Tween Bridge Solar Farm

8.32 Applicant Responses to Interested Party Responses to 3rd Written Questions

Document Reference: 8.32

Drawing Ref: Environmental Statement Volume 4, Figure 2.2b: Indicative Operational Layout Plan

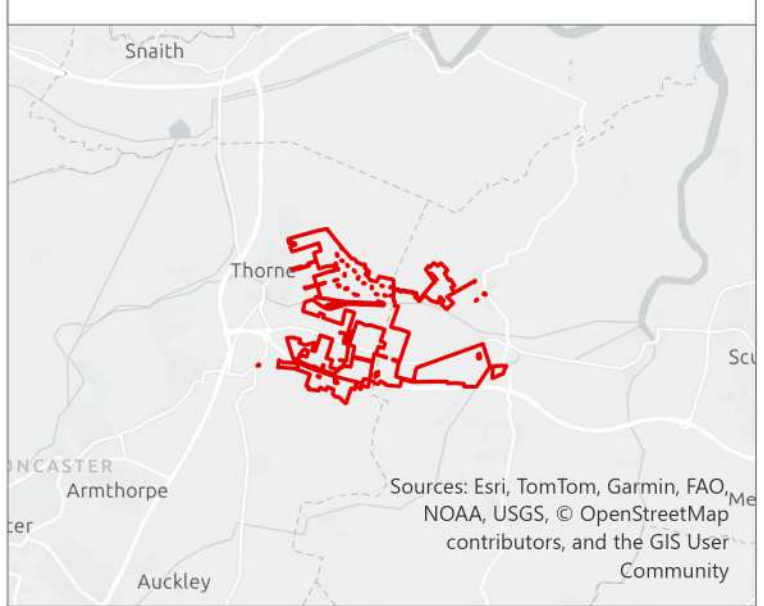
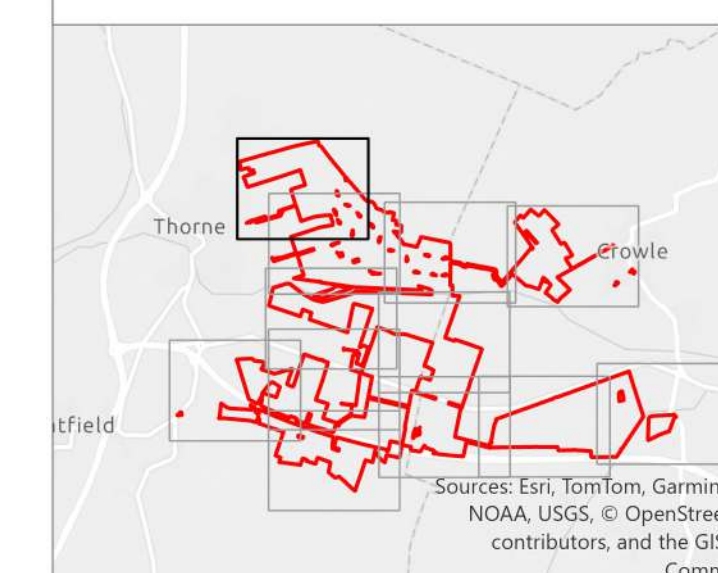
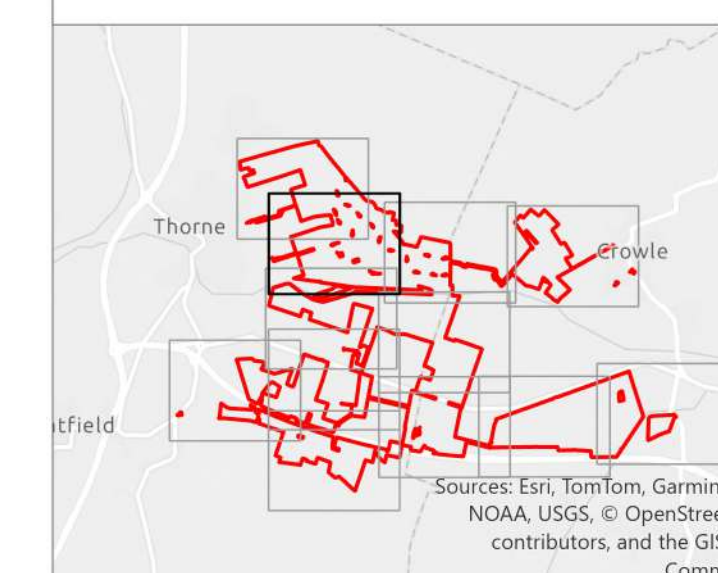
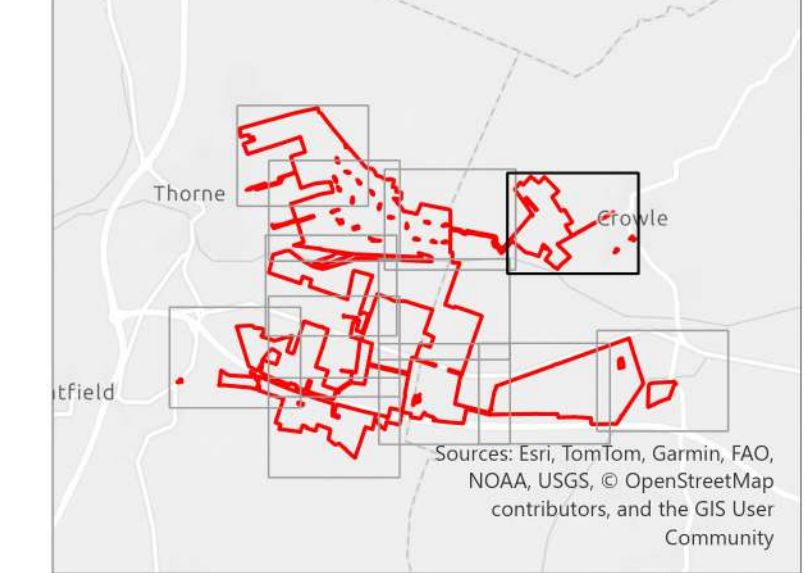
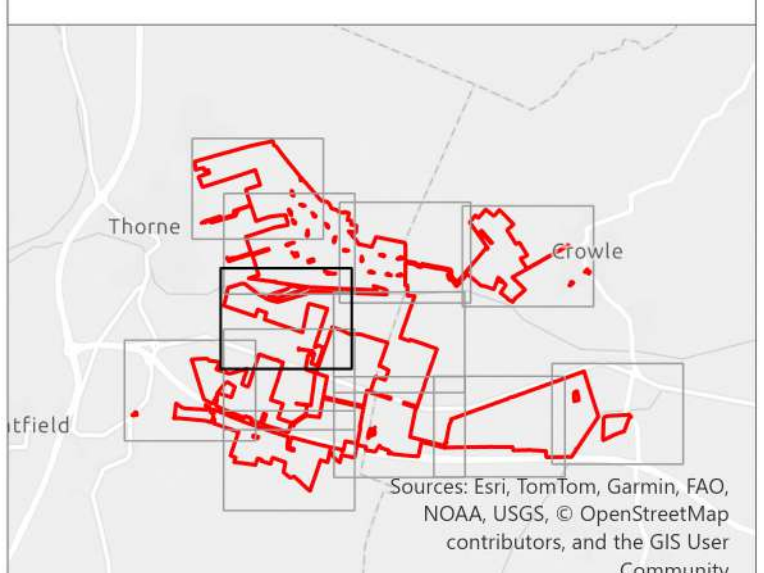
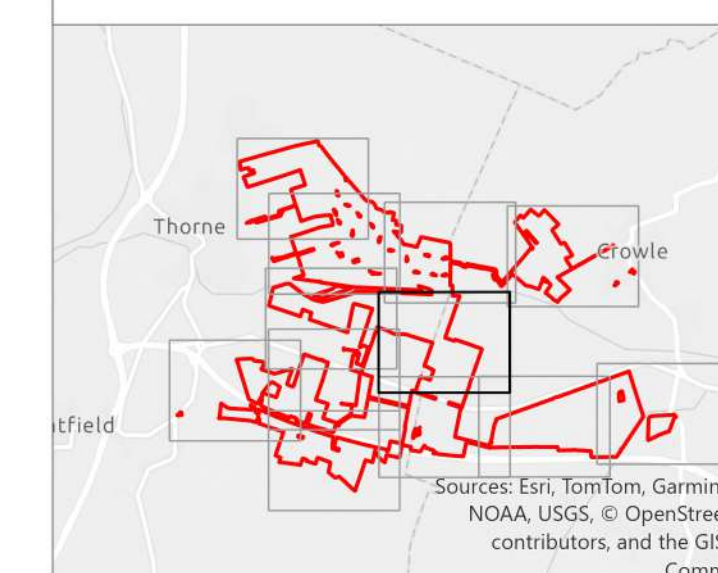
licence for GCN prior to construction, that this issue can be moved to a 'yellow'* issue and marked as resolved.	
Environment Agency [REP6-092]		
Q3.1.3	Changes to layout The EA welcomes the spatial refinements in respect of the 132kV substation and the 100MW BESS in relation to FZ3b. As confirmed in its Deadline 2 representation [REP2-102], the EA is satisfied that the Applicant has adequately demonstrated that there will be no increase in flood risk to third parties as a result of the proposed development. The design amendments do not alter the EA's view on this matter.	The Applicant notes and welcomes this comment.
Q3.7.1	Flood Plain Storage and Sequential / Exceptions Test	The Applicant notes and welcomes this comment.

The EA notes the revised layout and welcomes the removal of the 132kV substation from FZ3b. The EA has no objections or concerns relating to the revised layouts.	
Q3.14.1	Piling Method Statement The Environment Agency's original recommended wording for a separate requirement to secure a piling risk assessment and piling method statement is contained in our Relevant Representation [RR 009] at paragraph 3.9. We have since reviewed our recommended requirement and wish to update our suggested wording to the following: Piling and penetrative foundation design (1) No phase of the authorised development involving piling or penetrative foundation methods shall commence until a piling risk assessment and method statement has been submitted to and approved by the relevant planning	As confirmed in response to Q3.14.1 in Written Responses to ExQ3 [REP6-050], the Applicant's position is that the appropriate securing mechanism for this commitment is the Outline Construction Environmental Management Plan (CEMP) [REP6-032], which is intended to provide a comprehensive source of the mitigation and management measures that are required to be implemented during the construction of the Scheme, and which is secured through Requirement 14. The Applicant sees no reason why this particular commitment warrants an approach that differs from the wider suite of construction-stage mitigation commitments. The Applicant will however review and update the wording of the commitment within the Outline CEMP at Deadline 8 to align more closely with the EA's preferred Requirement.

proposed Local Plan content and evidence under Regulation 23. In this context, it is considered that the emerging Local Plan is not a relevant consideration in the determination of this DCO application.	
Q3.1.3	Changes to layout In respect of the removal of panels from fields E19 and E20, NLC notes the removal of panels in close proximity to Property 44 New Plains House and Plains House Farm and that the impact of the proposals on it would be reduced as set out in the revised ES Appendix 6.2 Residential Visual Amenity Assessment [Document Reference 6.3.6.2 Revision 2]. Please see NLCs response to Q3.8.1 below in respect of the RVAA and impacts on existing properties.	The Applicant notes and welcomes North Lincolnshire Council's (NLC) acknowledgement that the removal of solar panels from Fields E19 and E20 reduces the visual effects experienced at New Plains House and Plains House Farm, as identified within the updated Residential Visual Amenity Assessment [REP4-028]. The Applicant also welcomes NLC's acknowledgement that the relocation of the 132kV substation outside Flood Zone 3b is a positive amendment to the Scheme. In relation to flood risk and the location of infrastructure within Flood Zone 3b, the Applicant respectfully disagrees with NLC's conclusion that the proposed layout has not been robustly justified. As set out in the Flood Risk Assessment [REP5-014] at paragraph 5.29, the Scheme seeks to direct infrastructure towards areas of lower flood risk where reasonably practicable, whilst recognising the significant

The relocation of the 132kV substation outside of flood zone 3b is noted and welcomed. It remains NLCs position that it objects to the location of infrastructure in FZ3b without robust justification and NLC has particular concerns about the impact of BESS areas within Flood Zone 3b due to associated fire and pollution risk and about the potential local flood risk impact of the proposed 300mm gravel base for BESS, inverters and spare containers within Flood Zone 3b. NLC does not consider that the Applicant has adequately demonstrated that there are clear operational reasons requiring elements of the development to be located within Flood Zone 3b.	extent of flood risk constraints present across the Order Limits. The Applicant has demonstrated that the Scheme would remain safe for its operational lifetime, would not increase flood risk elsewhere and would incorporate appropriate mitigation measures. The Applicant also notes that matters relating to battery safety, pollution prevention and detailed surface water management would be secured through the proposed requirements within the Draft DCO [REP6-002] and respective management plans. The Applicant further notes NLC's acknowledgement that the reconfiguration of panels within Field E5 has reduced effects on the setting of Dirtiness Pumping Station and that any remaining harm would be at the lower end of the less than substantial range. The Applicant welcomes NLC's conclusion that such harm would be clearly outweighed by the public benefits of the Scheme.
